Subject: AB/12/21/PL -Old Bank House, 3 High Street, Arundel

Project:-	Old Bank House 3 High Street Arundel West Sussex		
Title:-	Block Plan		
Client:-	Moor Construction Ltd		
Scale:-	1:500 (@A3)		
Drawn By:-	PJD	Checked By:-	
Date:-	12/02/21	Date:-	
Job.No:-	200042	Drg.No:-	21

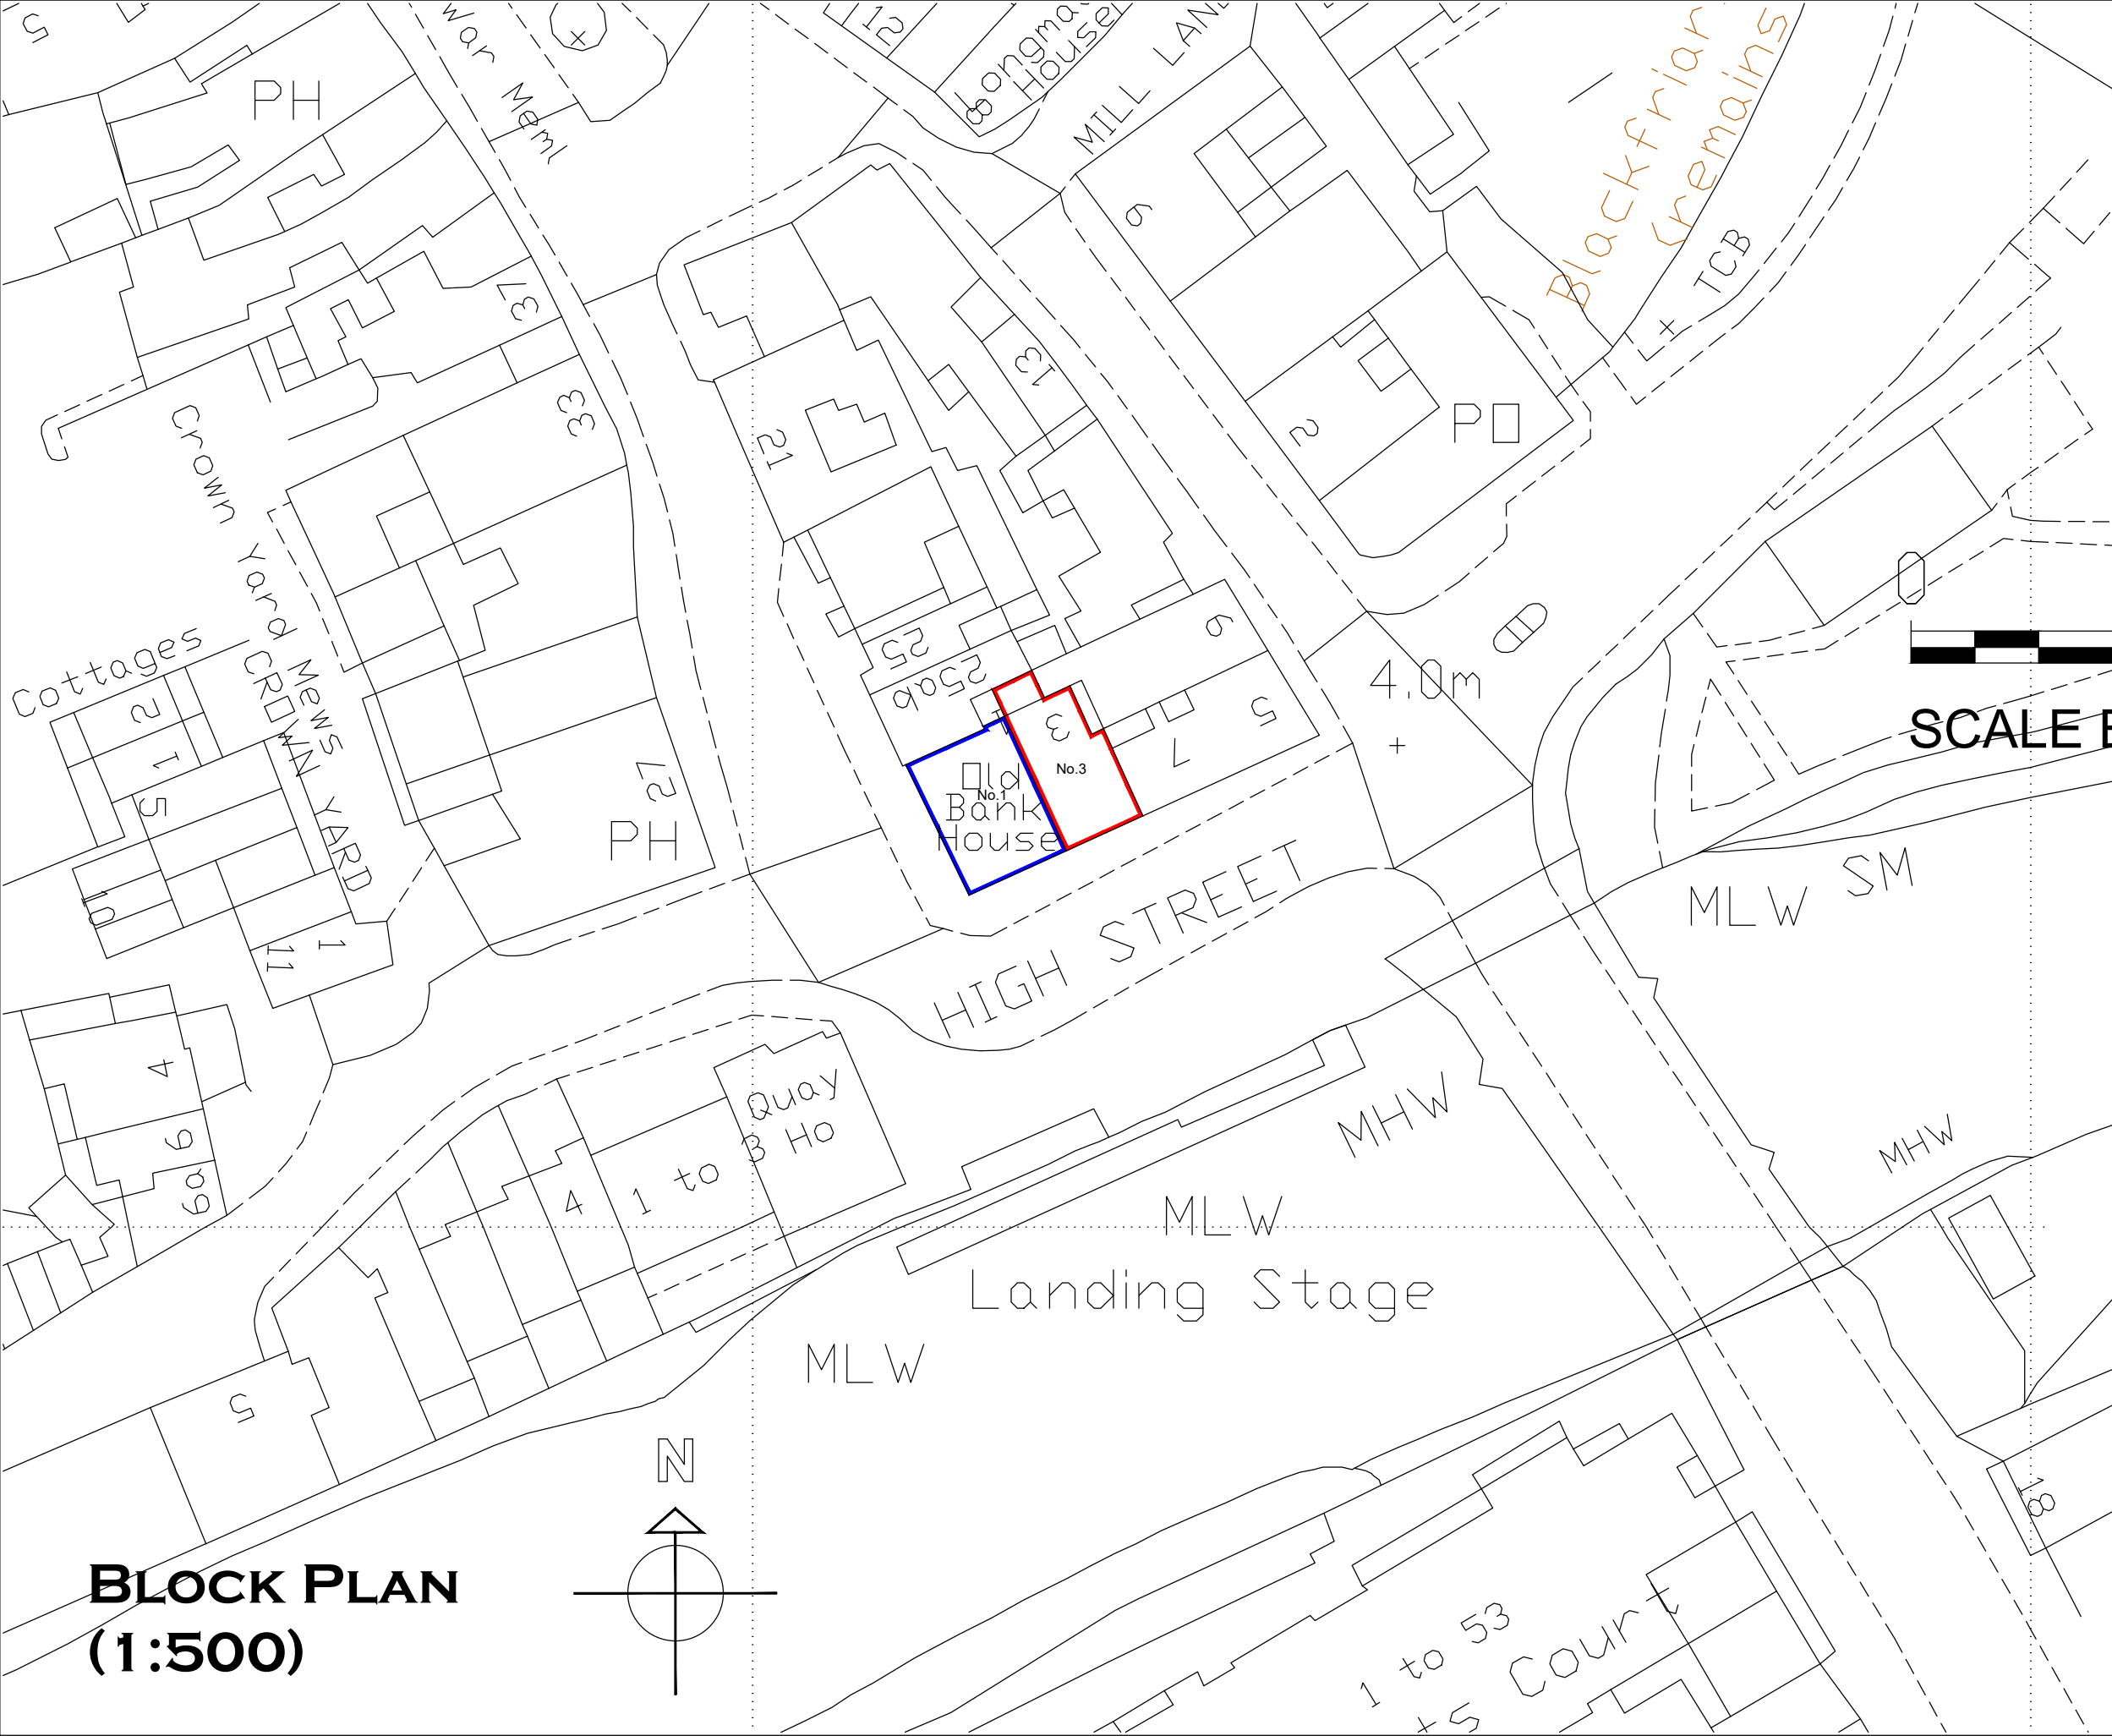
Following my e-mail to you last week I can confirm that your application has been put back on hold pending receipt of a revised a red edge plan and the correct certificate.

I note that the above application includes the provision of new steps on the pavement and that this area is excluded from the red edge of the application site. I apologise that this was not picked up at registration stage. I am therefore requesting that a revised floor plan and site location/block plan are submitted and Notice is served on WSCC as landowners and a new land ownership Certificate submitted. The application would be placed back on hold whilst this is undertaken, but we currently have no access to the planning database so this will be backdated from next week when the system is back up and running and the advertising period will be amended accordingly from receipt of this information.
